Application Ref:	2025/0795			 Ribble Valley Borough Council www.ribblevalley.gov.uk				
Date Inspected:	30/10/2025	Site Notice:	N/A					
Officer:	EP							
DELEGATED ITEM FILE REPORT:					APPROVAL

Development Description:	Proposed erection of a single-storey side extension and associated alterations.		
Site Address/Location:	21 Hawthorn Road Barrow Clitheroe BB7 9ER.

PROPOSED EAST ELEVATION
Scale 1:100

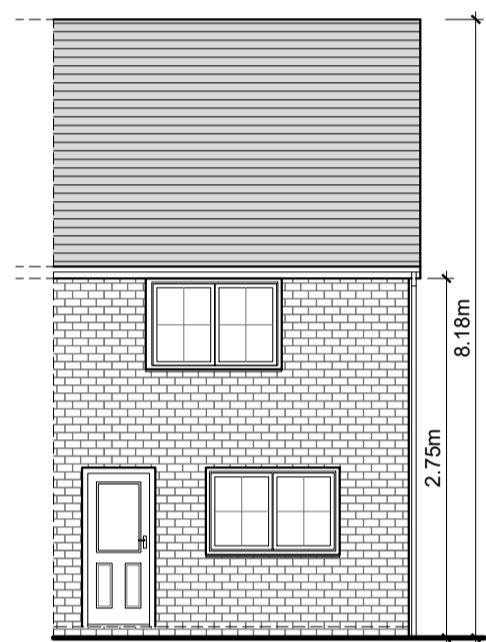
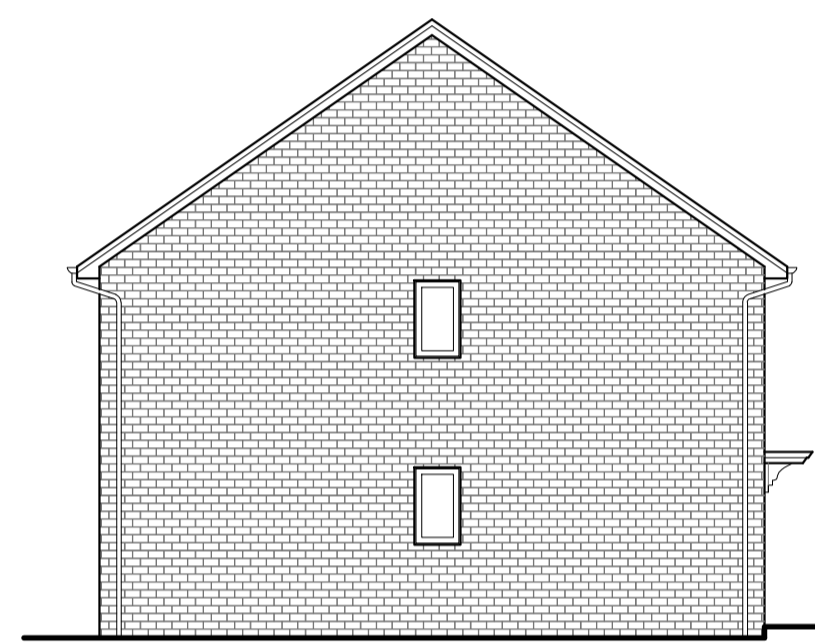
In regard to scale, the proposed footprint of the extension would be modest, measuring 2.1m by 6.6m with an eaves and ridge height of 2.6m by 3.3m respectively. The extension would also benefit from a set-back from the principal building line of the dwelling of 1.1m. As such, the extension, based on the scale and siting, would remain entirely subservient to the host dwelling.

In terms of materials, the extension will be constructed using facing brickwork to the elevations with concrete roof tiles, both to match the existing and properties in the vicinity. As such, the development will integrate sufficiently into the street scene.

PROPOSED SITE PLAN
Scale 1:200

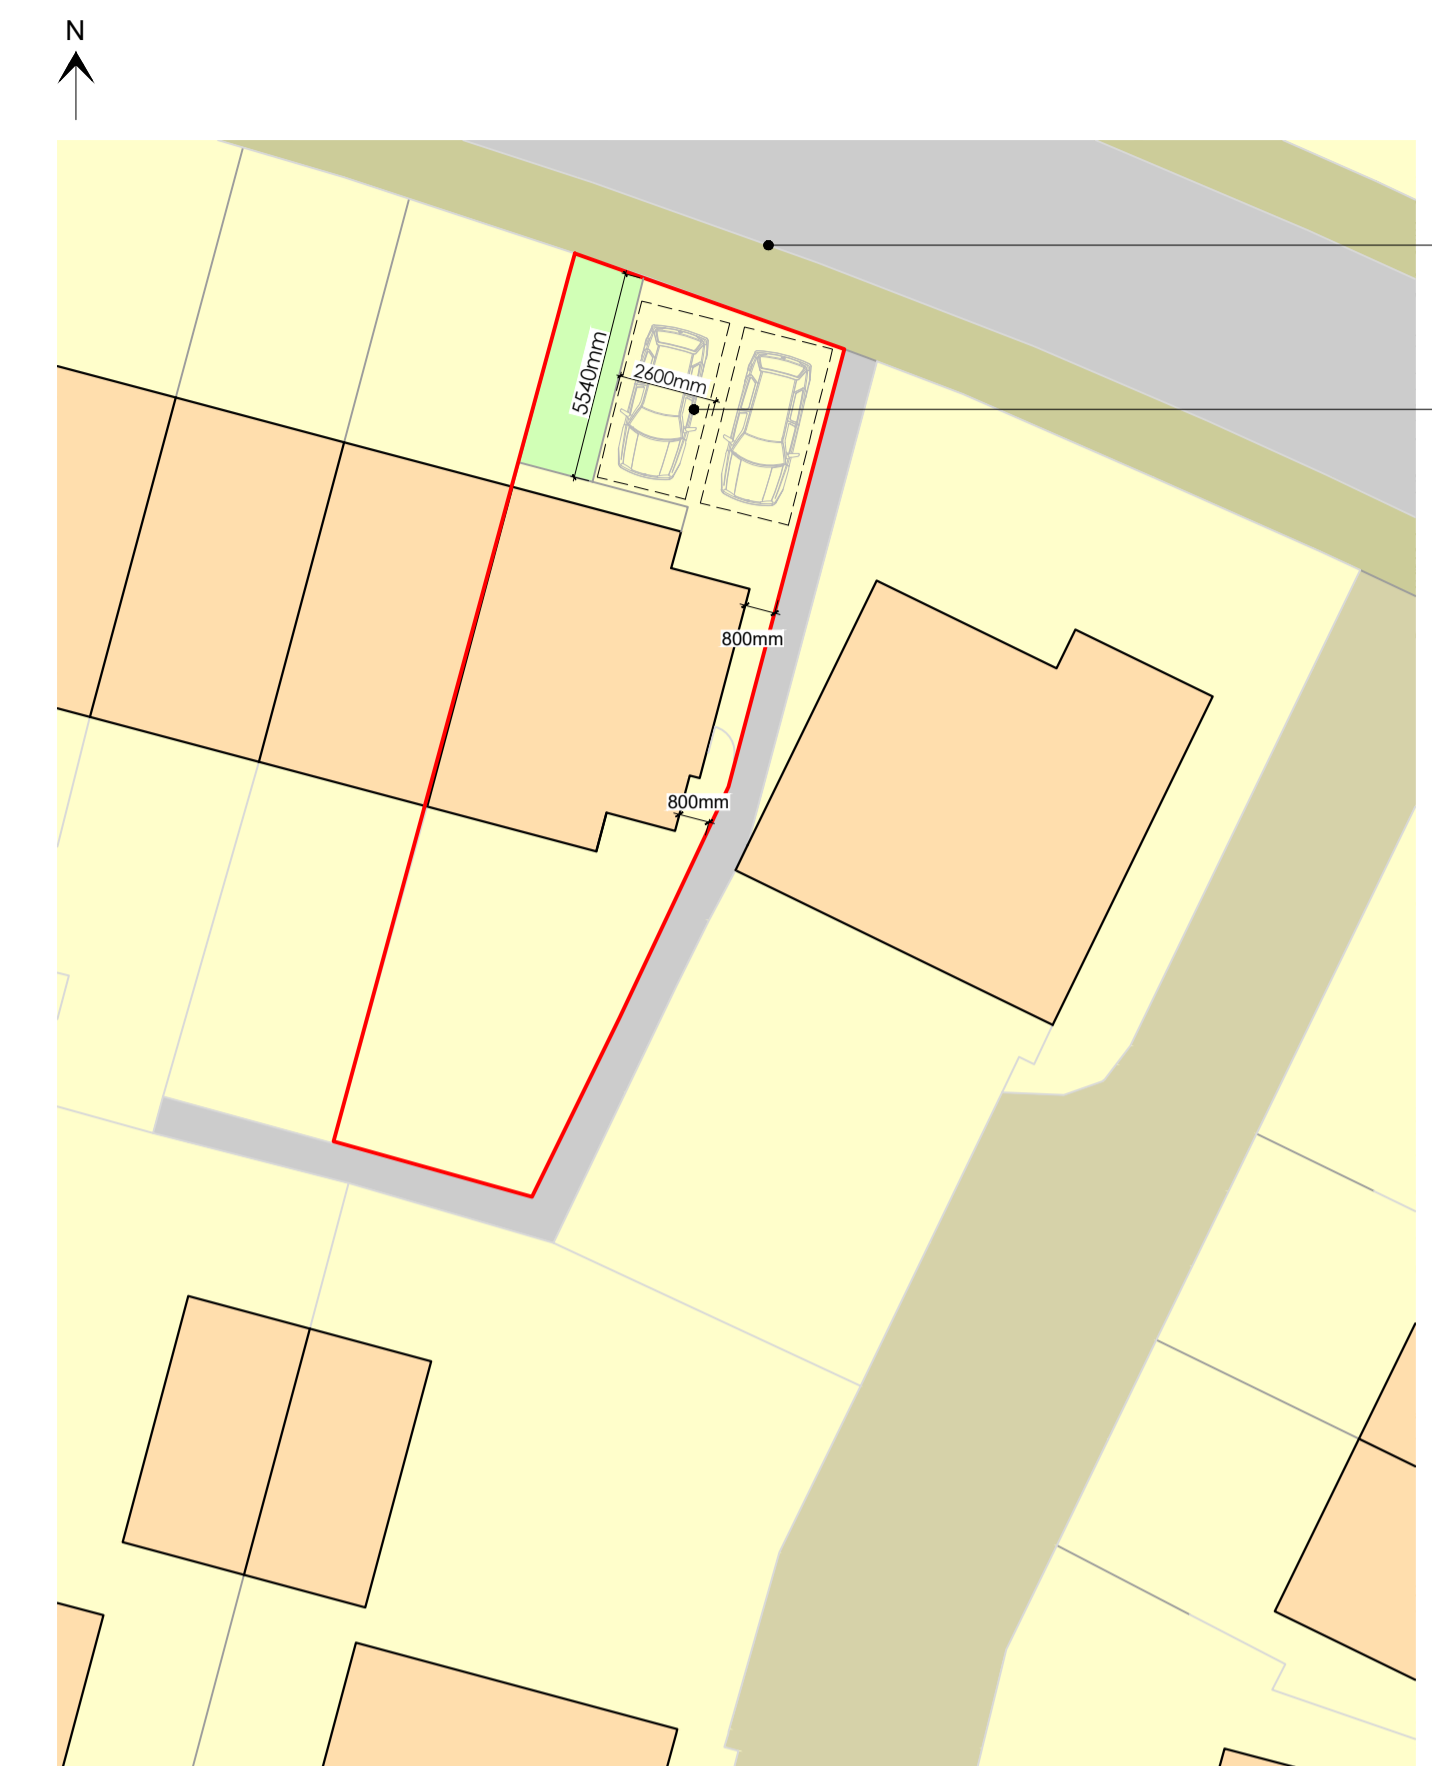
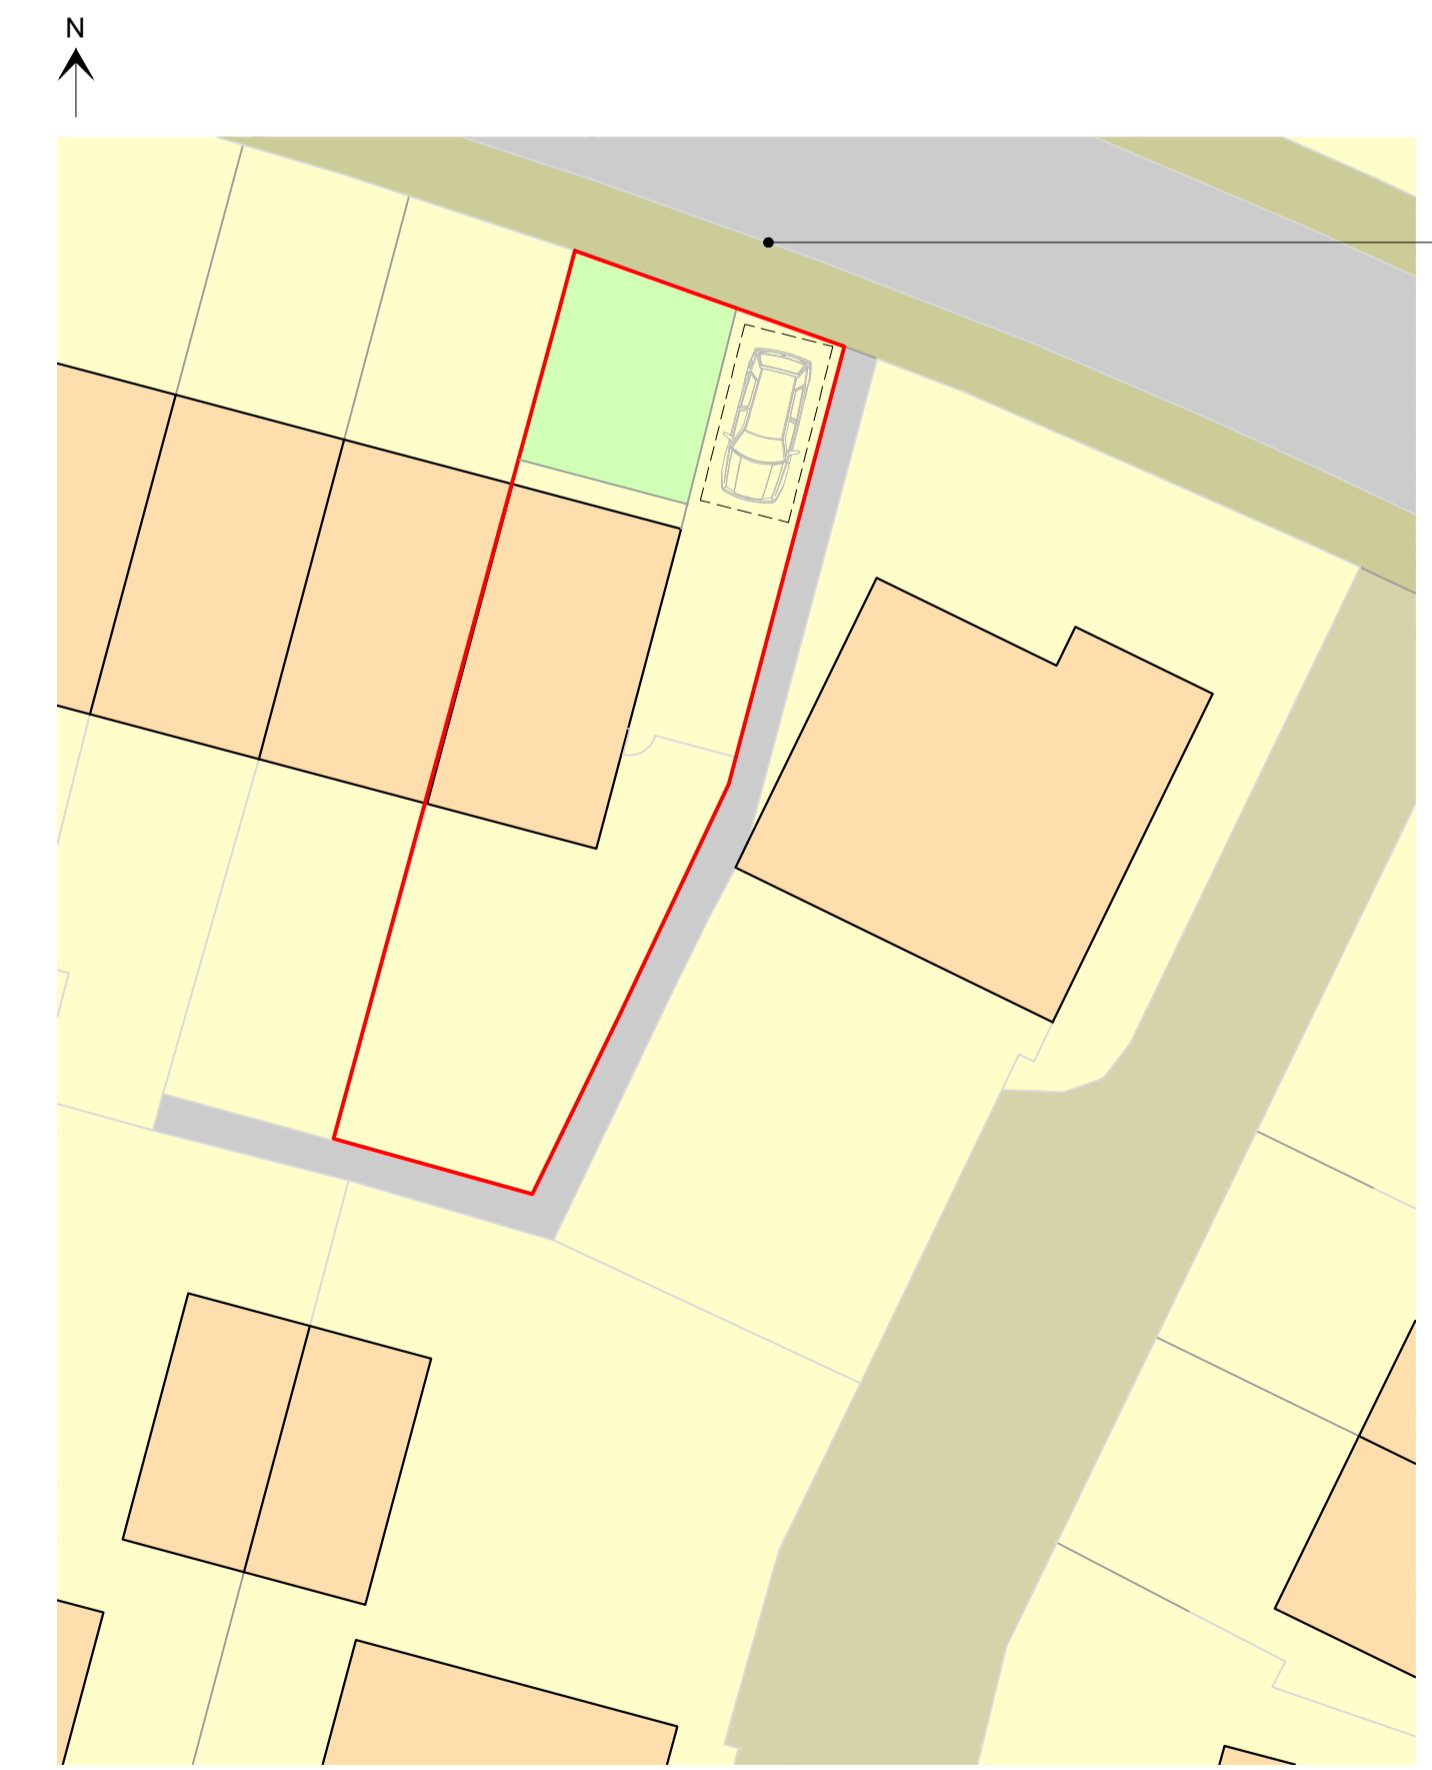
The proposed extension would result in the loss of one parking space; this will be off set via the widening of the driveway allowing for the introduction of an additional parking space to the front. A condition was placed on the original consent for this development securing the use of parking areas in perpetuity which has triggered the need for this application. Given the loss of parking has been off set, it is not considered there are any grounds for refusal on this basis. A similar condition to maintain the use of the newly proposed parking in the same manor will be enforced on the decision.
